PREPARED FOR  
**ACR SITE DEVELOPMENT PLAN**  
 705 CRESTFIELD GROVE  
 COLORADO SPRINGS, CO 80906  
 DUANE HAYS  
 (719) 338-9902  
 DUANE@HAYSCOMPANY.NET

ACR SITE DEVELOPMENT PLAN			
LANDSCAPE PLAN			
SHEET	1	OF	1
JOB NO.	25176.00

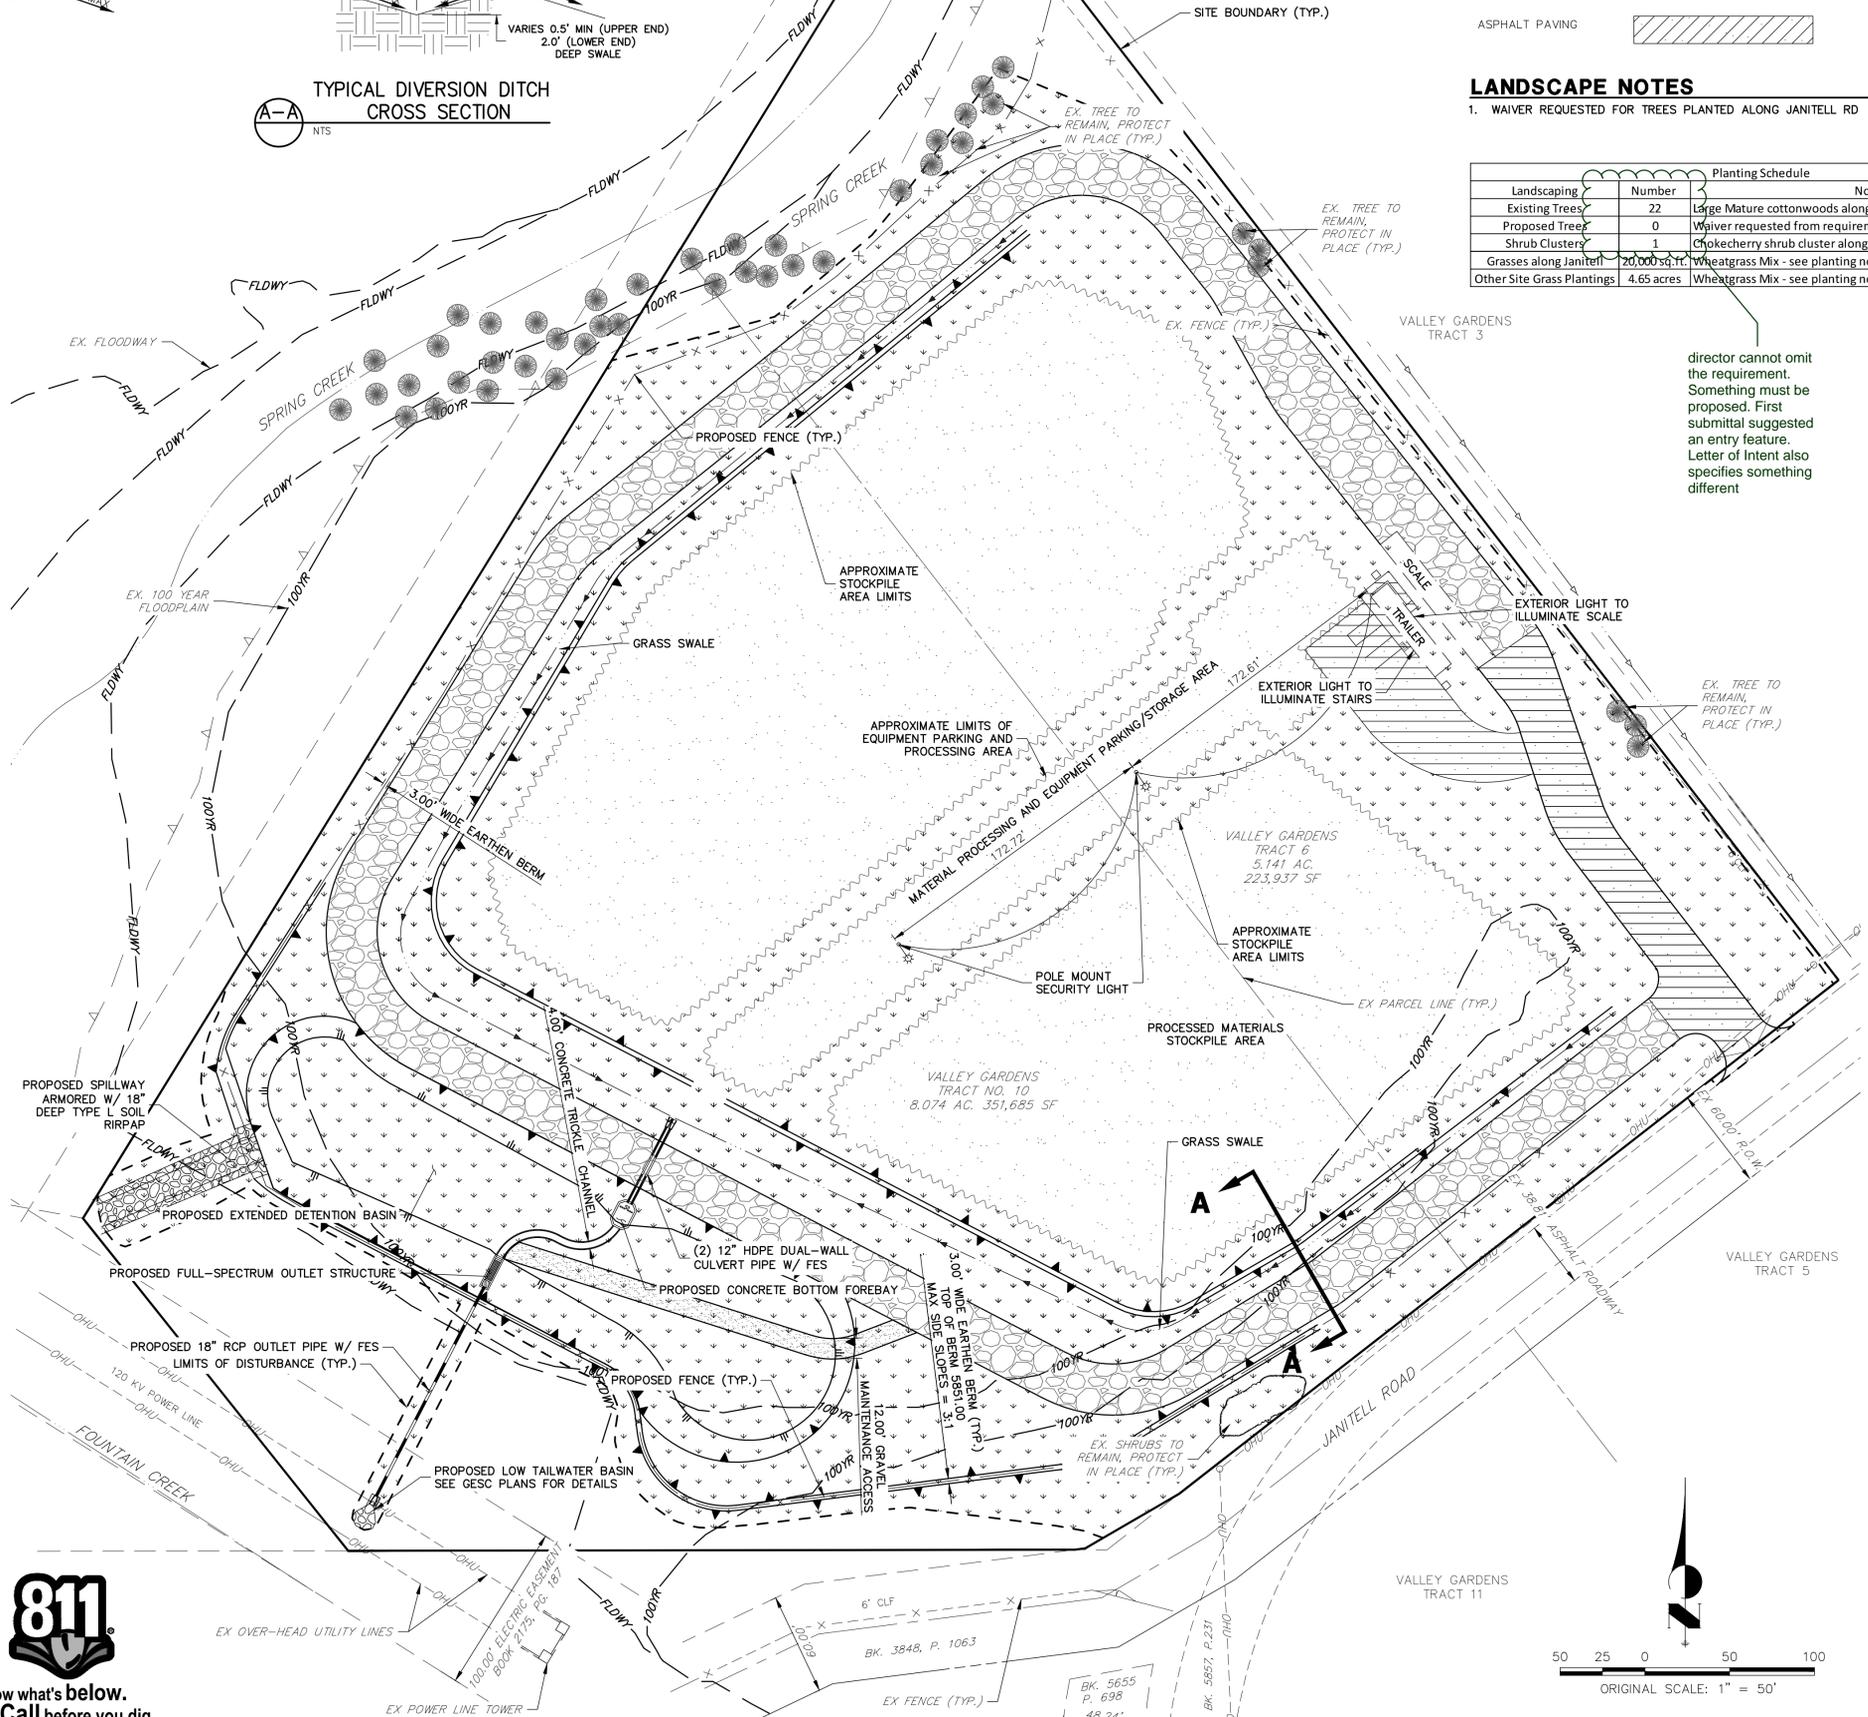
update LOI for waiver request, still awaiting director decision, however, an entrance feature requested.
